HE Proposition	RHS Position (see responses to Deadline 5 for further reasoning)	Highways England's response
1.0 Traffic and transport, including traffic modelling and assessment of alternatives

Appendix A. Design Standards – RHS Alternative: Wisley left out

Appendix B. Design Standards – RHS Alternative: Ockham Park Junction – South Facing Slips

MERGE (SOUTH SLIP)

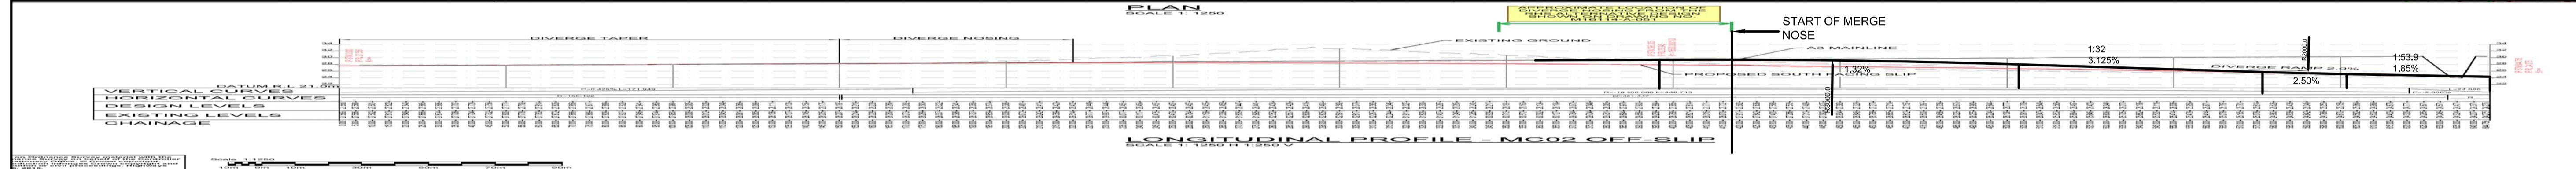
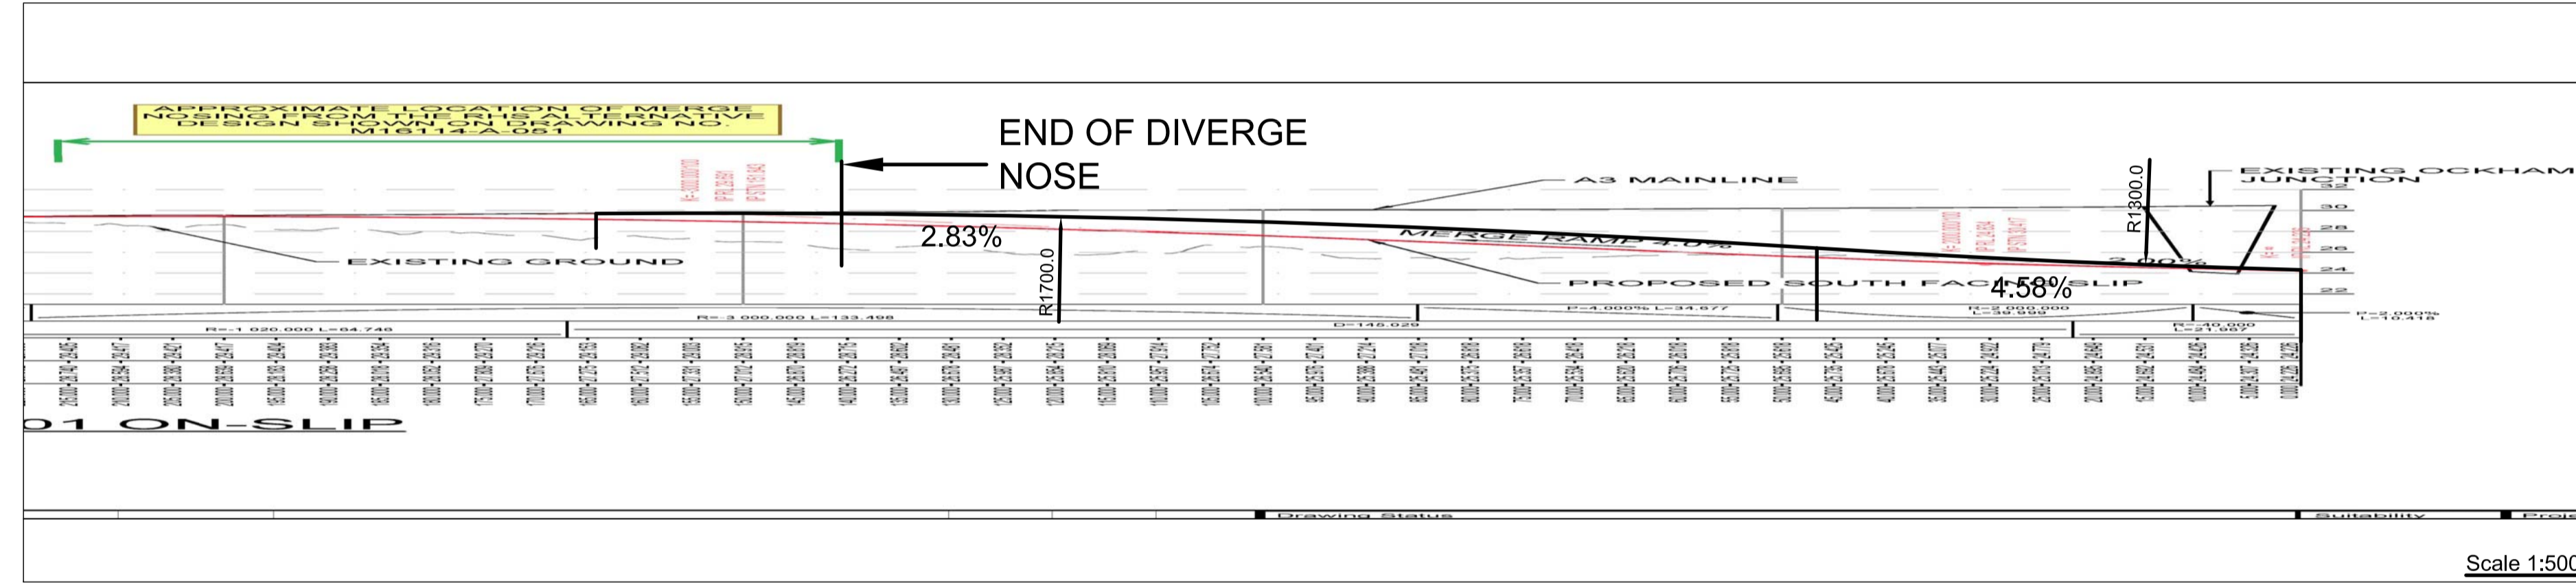
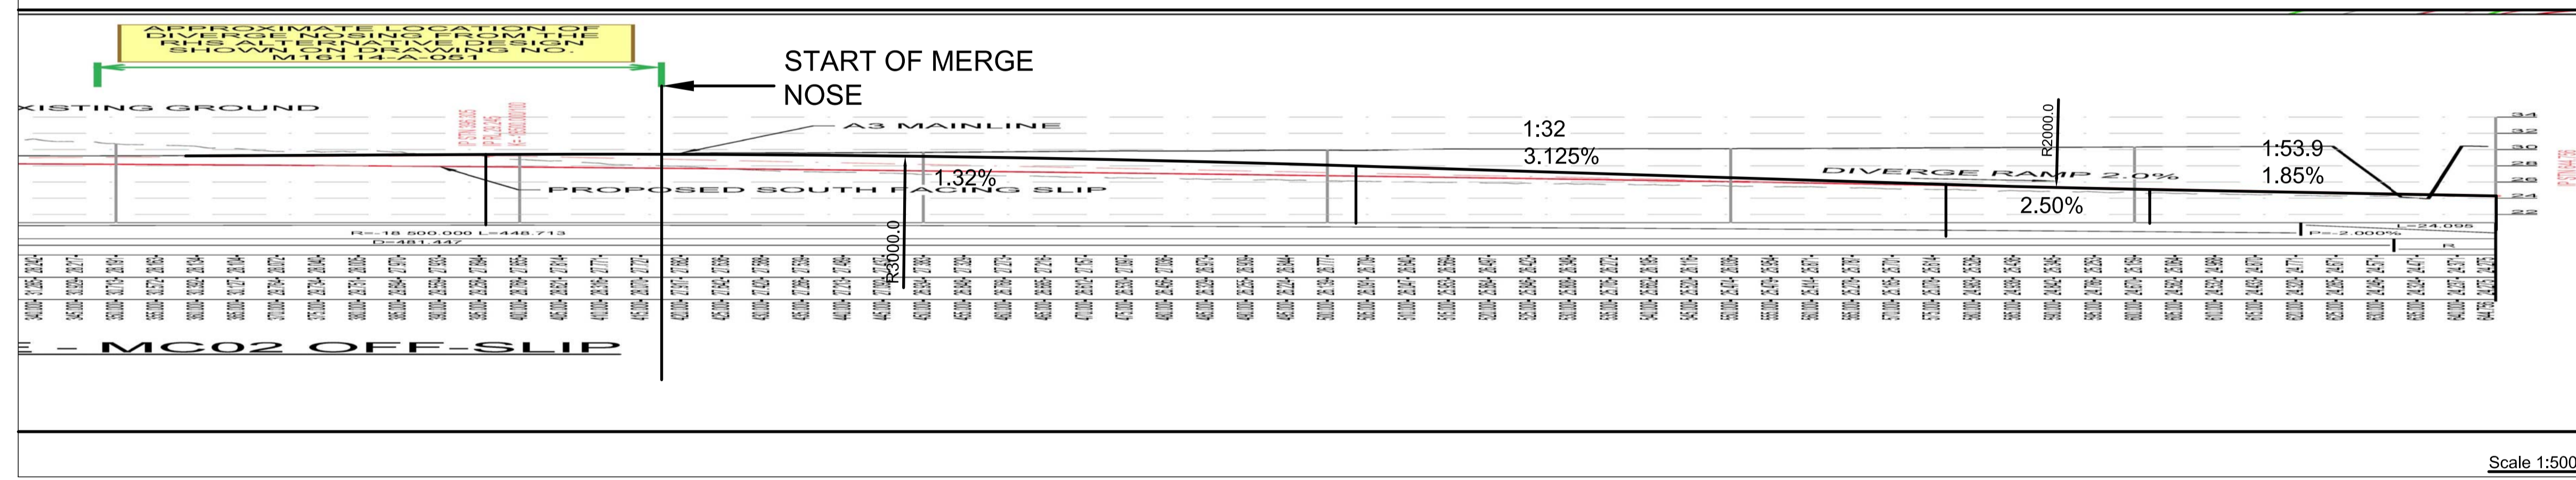
- a) The connector slip road linking the Ockham Park circulatory carriageway with A3 southbound mainline is not compliant with the requirements set out in the Design Manual for Roads and Bridges (DMRB); CD 122 - Geometric design of grade separated junctions. This is because:

- DMRB CD 122; paragraph 5.4 requires the slip road to be designed with a minimum design speed of 70kmph. The RHS Alternative design shows an insufficient length of slip road between the circulatory carriageway and the back of nose; it is not possible to fit the vertical geometry required by the design standards within this length.

- DMRB CD 122; paragraph 5.8 requires a length of near straight (with a radius no less than 1020m) to be provided at the back of nose, at least equal in length to the nose. The RHS Alternative design makes no allowance for a near straight.

- DMRB CD 122; paragraph 3.21 requires the nose length to be 85m. The RHS Alternative design provides a non-compliant 75m nose.
- b) The connector slip road linking the A3 southbound mainline with Ripley services is also not compliant with the requirements set out in DMRB CD 122 and CD169 - The design of lay-bys, maintenance hardstandings, rest areas, service areas and observation platforms. This is because:

- DMRB CD 169; paragraph 3.7 requires a separation of 450m between a lay-by and an at grade junction. The RHS Alternative design provides a separation of 420m between the existing lay-by and Ripley Services diverge.

- DMRB CD 122; paragraph 3.31 requires a minimum auxiliary lane length of 170m. The RHS Alternative design provides a non-compliant 150m for the auxiliary lane. If the minimum length were to be provided, it would require modification to the structure carrying Rose Lane over the A3.

- DMRB CD 122; paragraph 4.5 requires a minimum weaving length of 1000m between a full grade separated junction and a service area. The RHS Alternative design shows a weaving length of just over 1km, but as detailed above, other aspects of the design are not compliant. In addition, the RHS Alternative design has shown the notional merge and diverge to be less than the required 150m. To make the RHS Alternative design compliant, the weaving length would need to be significantly less than 1km

- a) The distance between the existing lay-by located on the A3 Northbound between Ripley services and the diverge to the Ockham Park junction does not comply with CD169 - *The design of lay-bys, maintenance hardstandings, rest areas, service areas and observation platforms*. This is because:

- DMRB CD 169; paragraph 3.7 requires a separation of 450m between a lay by and an at grade junction. The RHS Alternative Design provides a separation of 370m which does not comply.

- b) The connector slip road linking the A3 northbound to the Ockham Park junction is not compliant with the requirements set out in DMRB CD 122. This is because:

- DMRB CD 122; paragraph 5.8 requires a length of near straight (with a radius no less than 1020m) to be provided at the back of nose, at least equal in length to the nose. The RHS Alternative design makes no allowance for a near straight.

- DMRB CD 122; paragraph 5.4 requires the slip road to be designed with a minimum design speed of 70kmph. The RHS Alternative design shows an insufficient length of slip road between the circulatory carriageway and the back of nose, it is not possible to fit the vertical geometry required by the design standards within this length.

- DMRB CD 122; paragraph 3.33 requires the mainline Stopping Sight Distance (SSD) [295m] to be provided along the slip road up to the give way line at the circulatory carriageway. The slip road leading from the A3 northbound to the Ockham Park junction as shown on the RHS Alternative design is not of a suitable length to provide the vertical geometry required to achieve the SSD.

- c) DMRB CD 122; paragraph 4.5 requires a minimum weaving length of 1000m between a full grade separated junction and a service area. The RHS alternative design shows a weaving length of just over 1km but as detailed above other aspects of the design are not compliant. In addition, the RHS alternative design has shown the notional merge and diverge to be less than the required 150m. To make the RHS alternative design compliant, the weaving length would need to be significantly less than 1km
